The Turner Family, Representation to Planning Inspectorate A303, CPO process May 2019.

This submission is made in respect of the invitation for written representations (Examination Timetable deadline 2) and as owners / occupiers of land and property that will be severely affected by the road scheme proposals.

PLAN 1.B

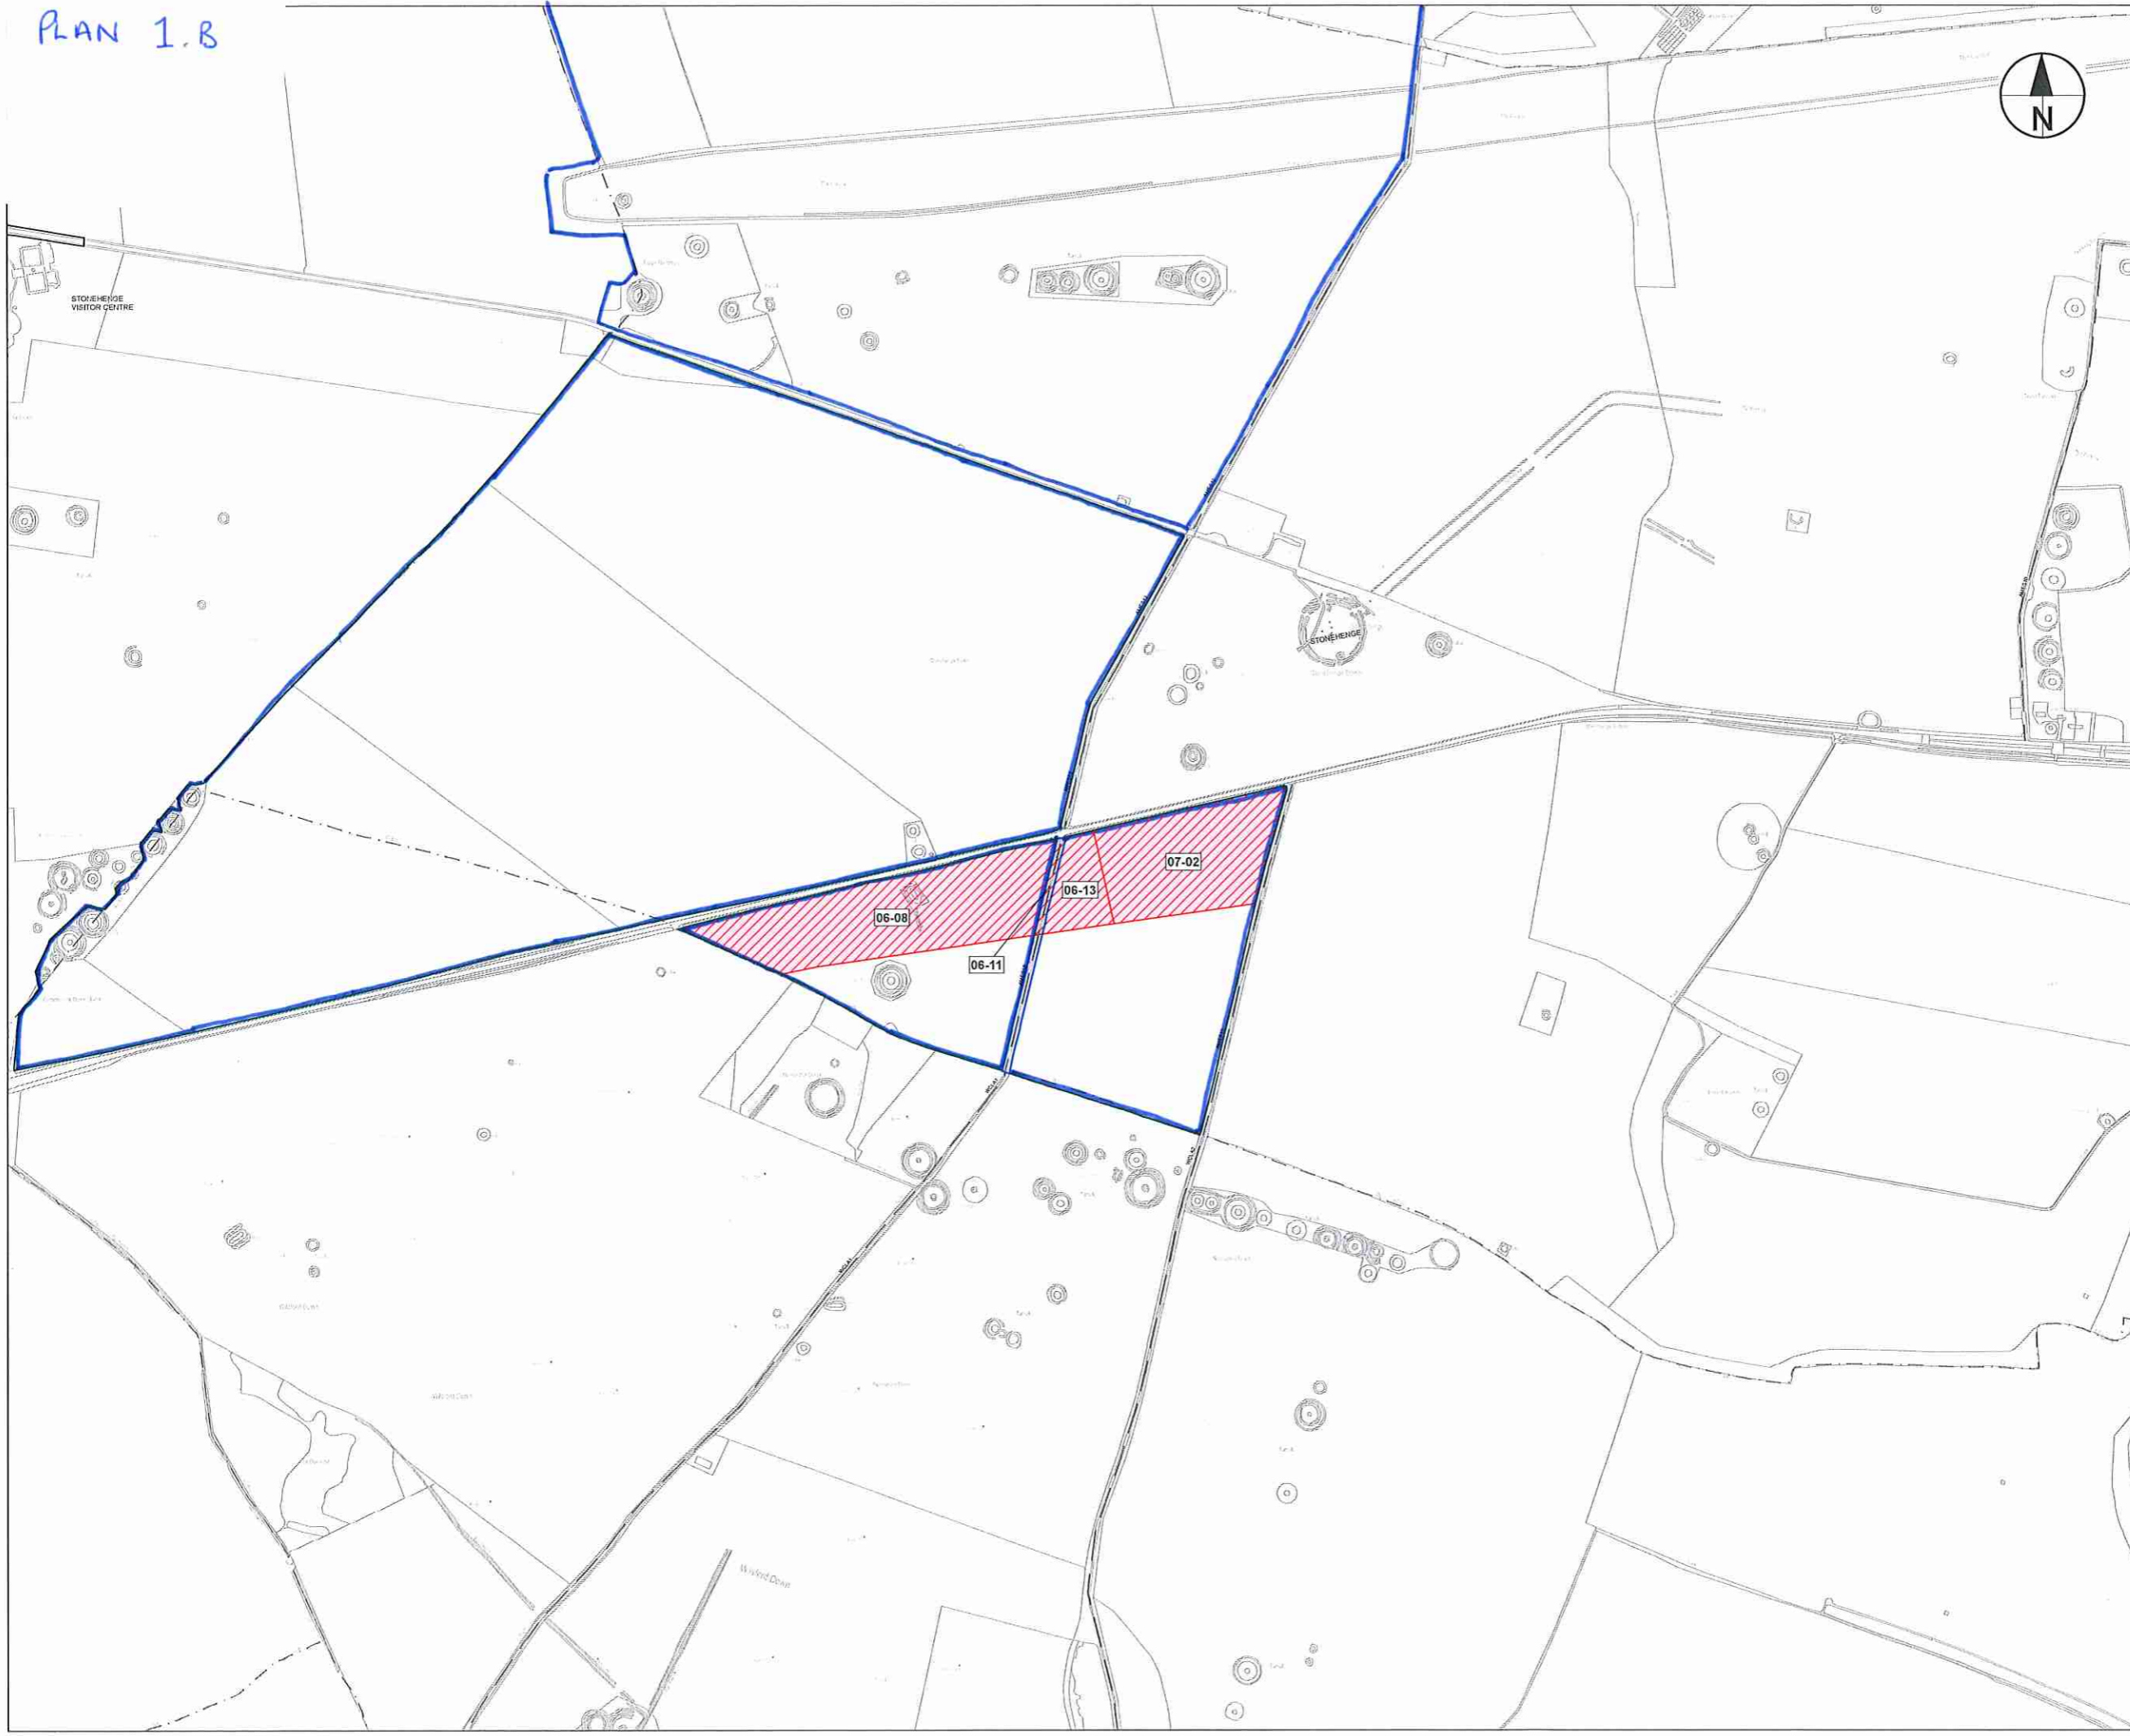
Ag.1.23	<p>Agricultural land (land ownership and severance) Please provide information, including annotated maps, showing the agricultural land interests within, and immediately adjoining, the proposed Order limits to include: i. land owned and tenanted by each affected agricultural business; and ii. highlight any areas where land would be severed by the Proposed Development.</p>	<p>Please see above and annotated plans.</p> <p>i. The entire holding suffers some degree of severance (see overview plan) causing the following reductions to farm profitability:</p> <ul style="list-style-type: none"> • short field working • isolated crossing points leading to increased travel time, fuel consumption & wear & tear of machinery <p>ii. the proposed alignment also leaves unworkable pockets of land where field boundaries have changed.</p> <p>iii. Where the holding was previously ring fenced the scheme has now created delinked pockets of land and field enclosures.</p>	Plan1 (A&B)

<p>The proposed acquisitions could be reduced to a lesser area. In particular;</p> <ul style="list-style-type: none"> • The extent of the compounds should be scaled back or removed from the holding. • The settlement ponds should be reduced in size or redrawn to minimise land take. It is understood that the size and extent of settlement ponds in the vicinity of Countess Roundabout have been minimised through the use of absorbent replenishable materials. We request that this approach should be replicated for those ponds positioned along the length of the project. • Boundaries could be realigned more efficiently. 	Acquisition	Ha	Ac	Percentage of Holding	Permanent	36.51	90.22	6.44 %	Temporary	73.74	182.21	13.02 %	Temporary & Subject to Permanent Rights	1.11	2.74	0.19 %	TOTAL	111.36	275.17	19.65%	
Acquisition	Ha	Ac	Percentage of Holding																				
Permanent	36.51	90.22	6.44 %																				
Temporary	73.74	182.21	13.02 %																				
Temporary & Subject to Permanent Rights	1.11	2.74	0.19 %																				
TOTAL	111.36	275.17	19.65%																				
	<p>Would the National Farmers’ Union and other parties state the extent to which the assessment methodology of the effects upon the different holdings as set out in Chapter 13 of the ES and Table 13.22 (during construction) and 13.23 (during operation/post construction) are agreed and provide evidence to support any disagreement?</p>	<p>Please note that The Environmental Statement (Chapter 13 Table 13.16) Summary of characteristics of agricultural holdings is incorrect. The table states that Manor Farm is an arable and beef holding. There is a distinction between ‘beef’ (finishing cattle) and ‘suckler herd’ (breeding cattle) the later operation is more significantly affected by the impacts of severance (as explained above).</p> <p>We strongly contest the portrayal of information contained within table 13.23 of The Environmental Statement (Chapter 13). This table summarises the permanent effects of the scheme upon the holding and concludes that the lasting effects of the scheme upon the farm is only minor or negligible. This is startlingly incorrect and shows a complete lack of understanding of our business operations. The permanent loss of 90 acres can surely not ever be ‘minor’ for a family run farm. The extent of the severance is evident from looking at Plan 1, and we have detailed above how this degree of severance will impact upon the farm.</p>	<p>Plan1 (A&B)</p>
